**TOWER 2, LEVEL 23  
DARLING PARK, 201 SUSSEX ST  
SYDNEY NSW 2000**

## **SSD 16\_7683: NEW RESTAURANT AND MICRO-BREWERY, OVERSEAS PASSENGER TERMINAL (TENANCY 5)**

**HERITAGE OBJECTION: SSD 16\_7683  
PROPOSED BREWERY AND OUTDOOR BAR  
TENANCY 5, OVERSEAS PASSENGER  
TERMINAL, CIRCULAR QUAY**

drawing title	View Impact Analysis View 3 Plan - Hyatt Hotel
scale date drawn by	1:2500@A3 july 2016 cb
drawing number+ revision	257_ADA_089 A

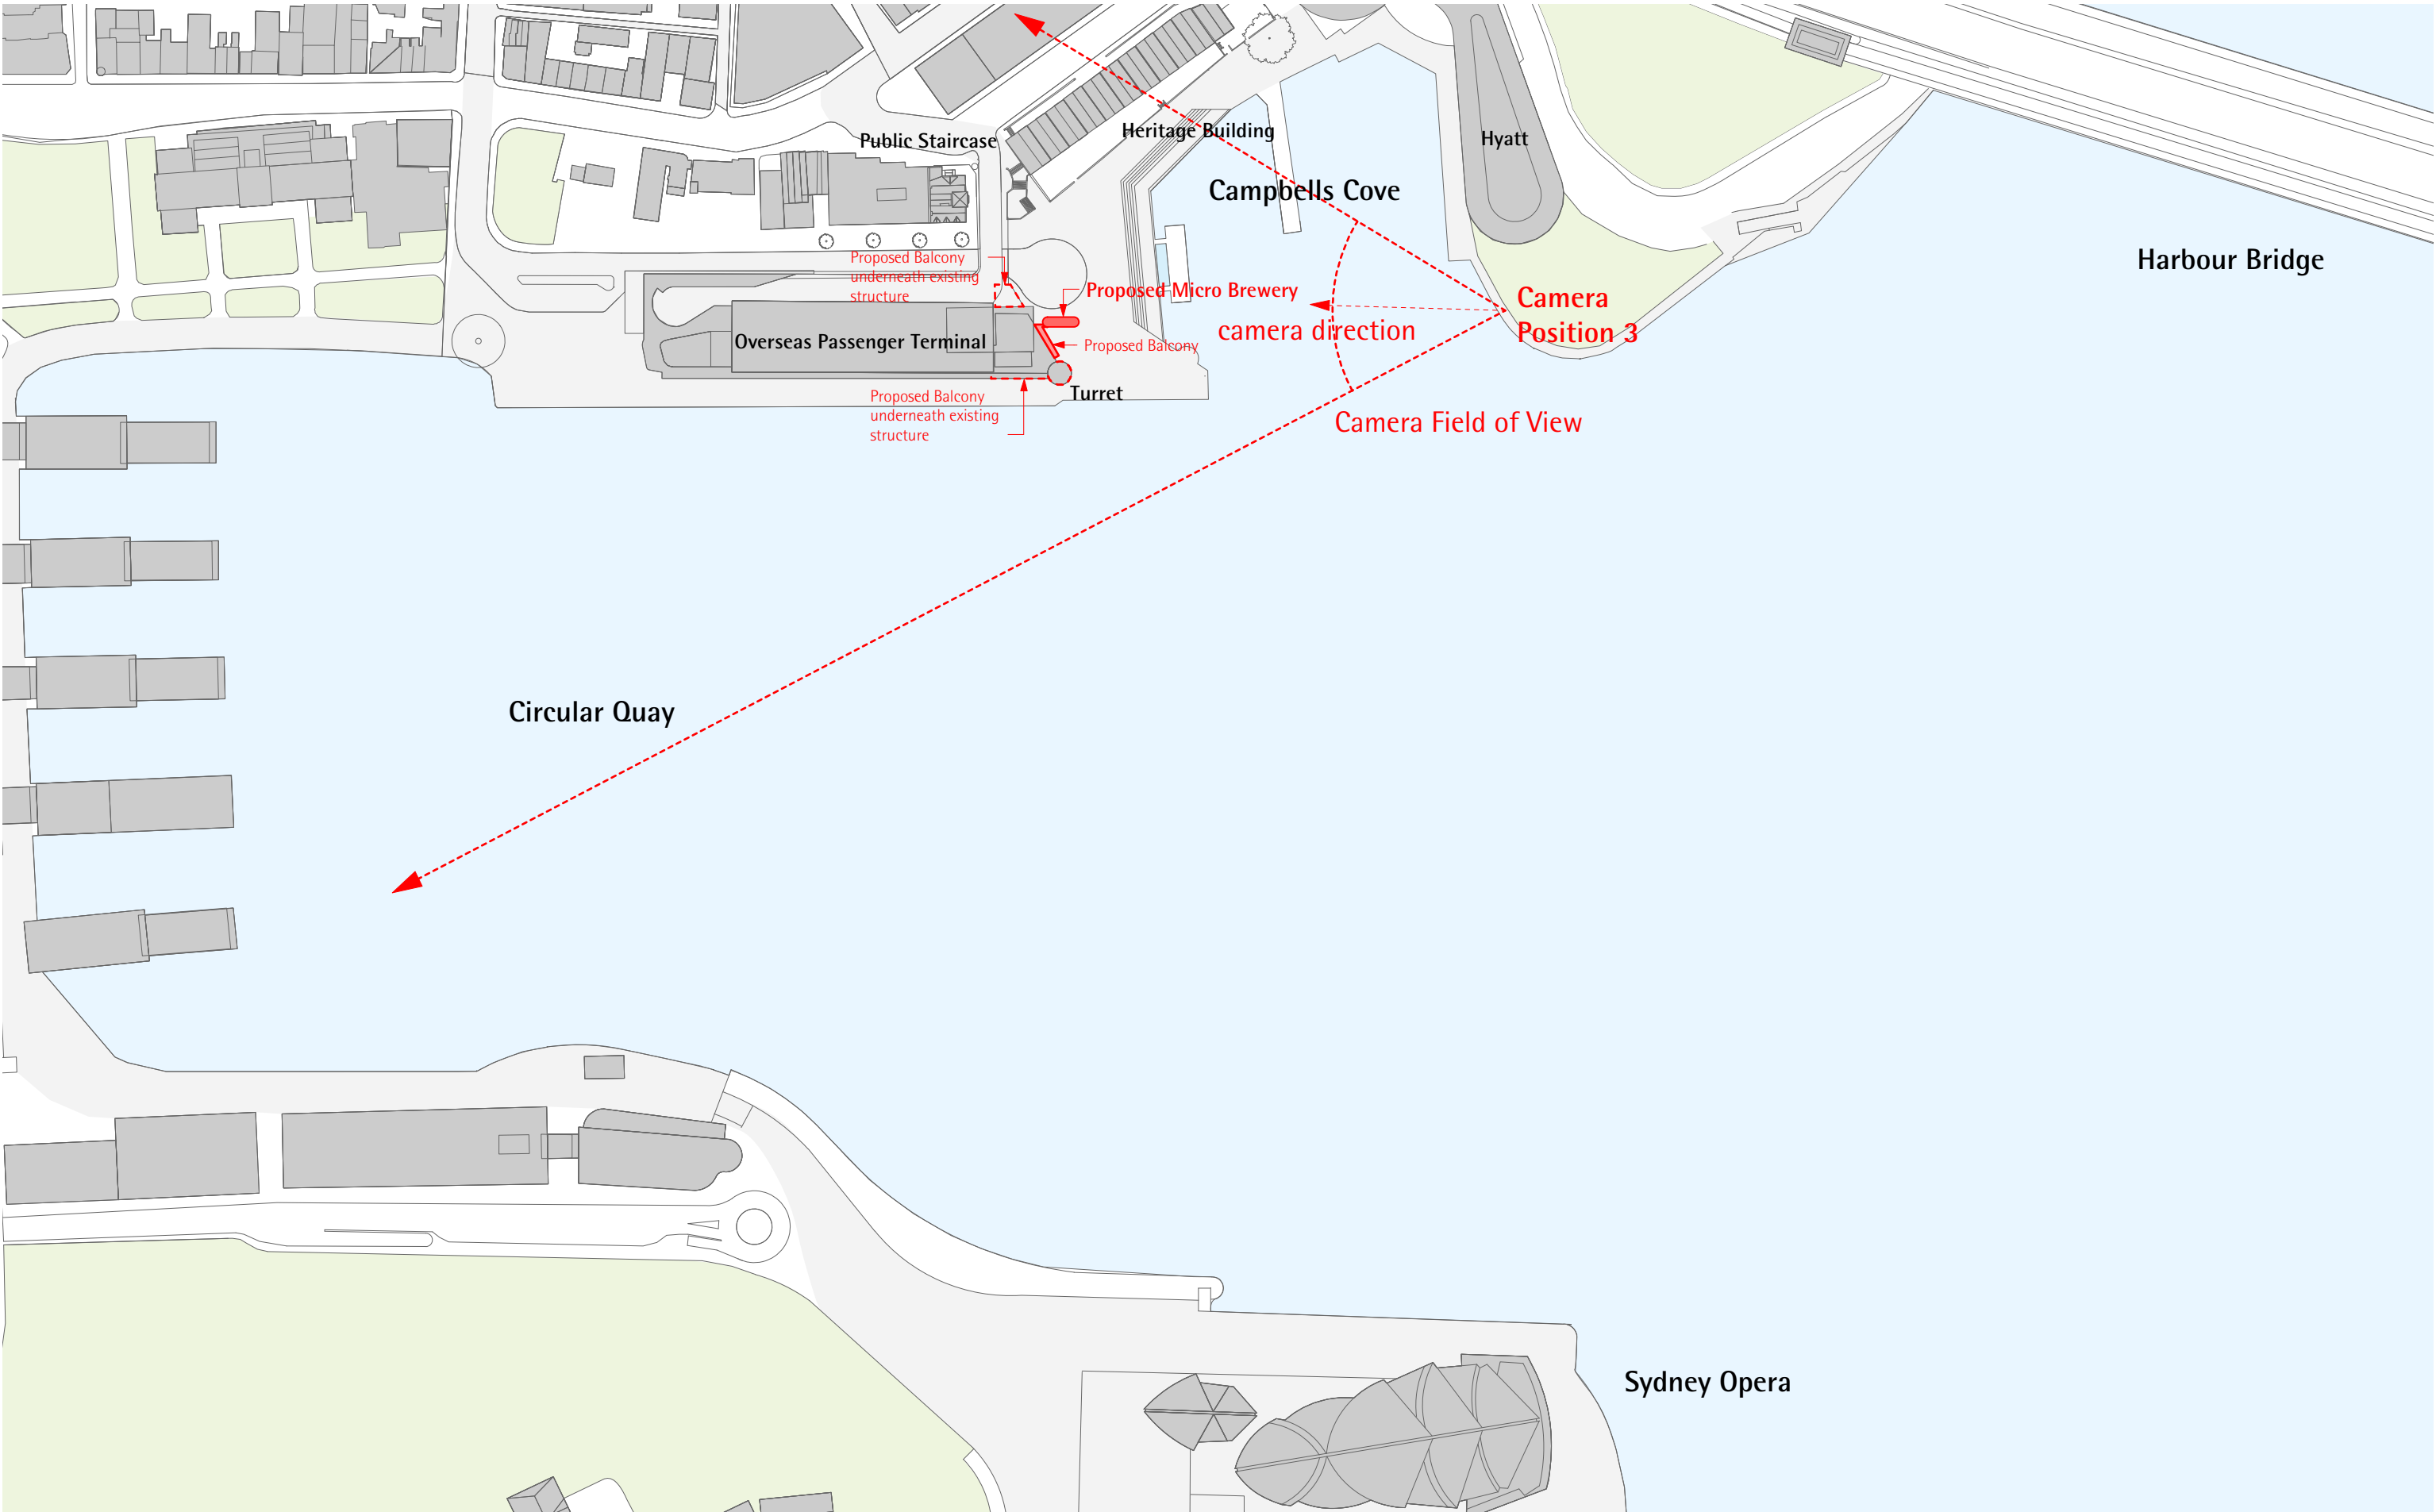
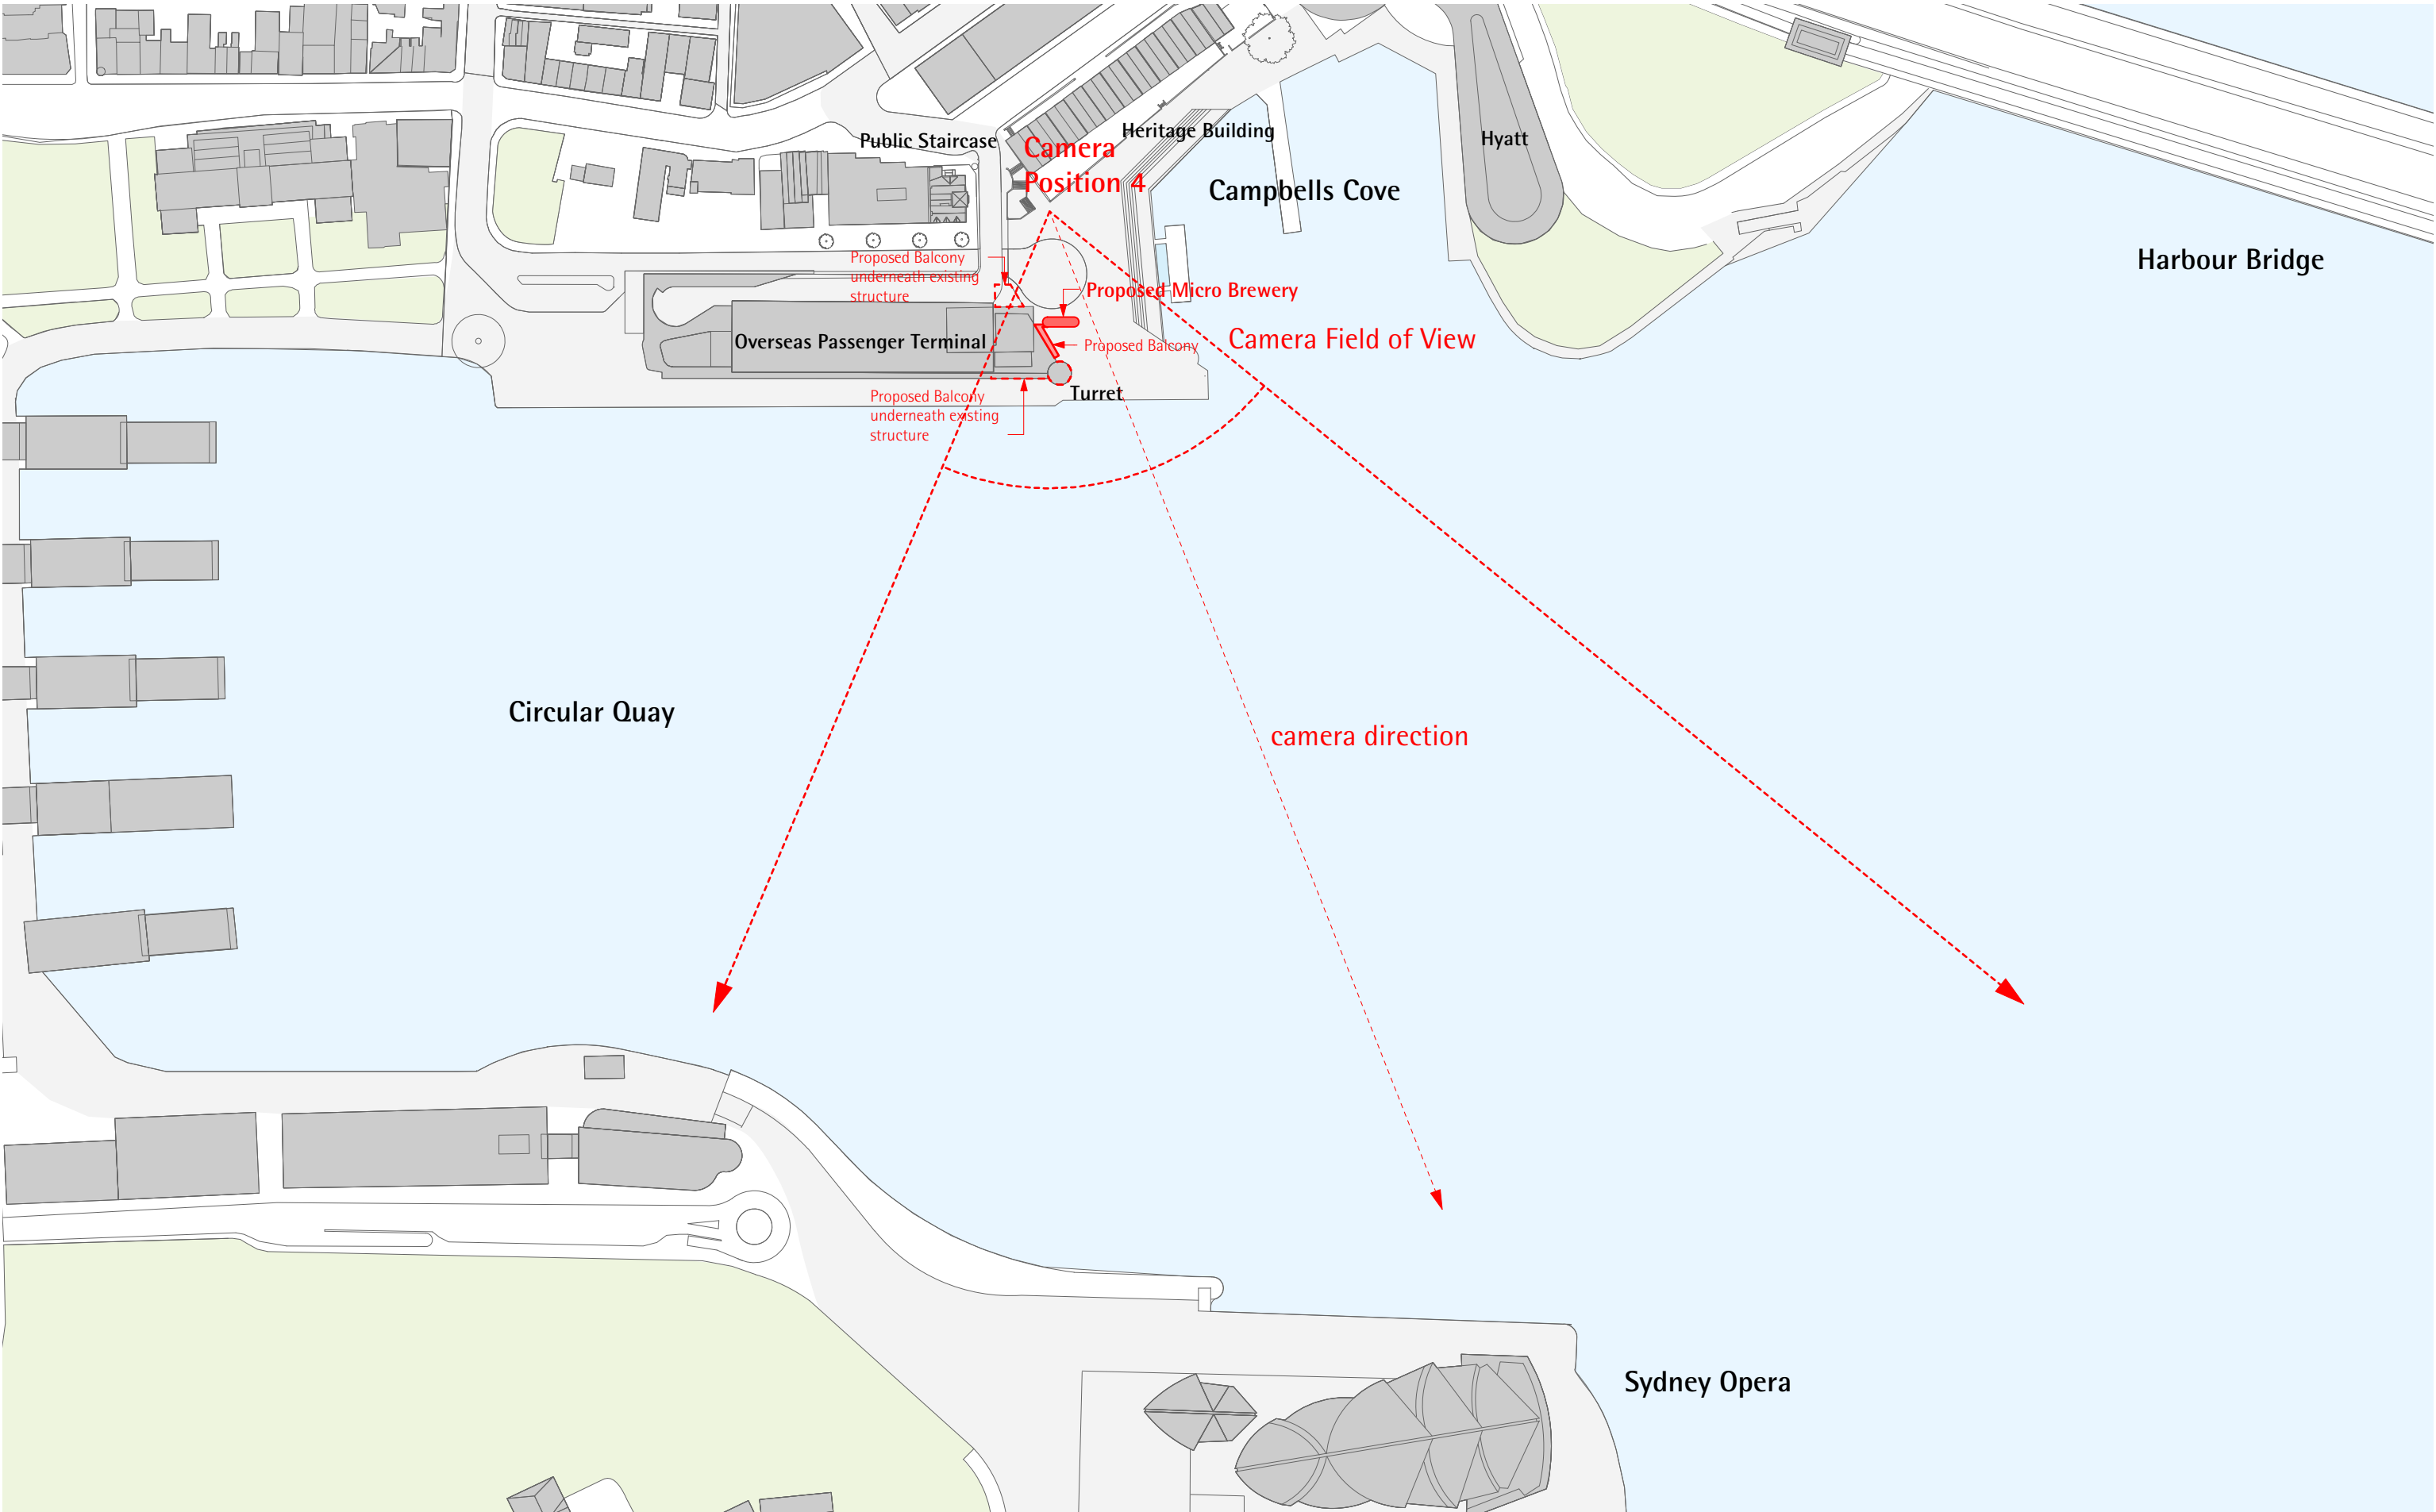
The visual impact analysis undertaken by the applicant is grossly inadequate. The five photomontages produced do not accurately show the proposed development in its entirety. The applicant has made the conscious decision to exclude elements such as the external tables, chairs, balustrades, landscaping and shade structures to reduce the amount of visual clutter.

Further, the five photomontages do not provide an accurate representation of the current and proposed views to and from the Sydney Opera House, Sydney Harbour, Campbell's Cove, and Campbell's Stores. The Department should request that a visual impact assessment be undertaken in accordance with the Land and Environment Court requirements so that the full extent of view loss can be considered.

The Environmental Impact Statement acknowledges that *"views of the Sydney Opera House from the eastern end of Campbell's Stores will be partially impacted by the proposed pod structure"*. We question the validity of this statement given the inadequacy of the visual impact assessment prepared. It is our opinion that views of the Sydney Opera House and Sydney Harbour from the eastern end of Campbell's Stores, including the Bay X public stairs, Bay 1 and Bay 2, and the outdoor dining areas will be significantly impacted by the proposed development. Furthermore, views will also be significantly impacted from the Campbell's Cove public promenade.
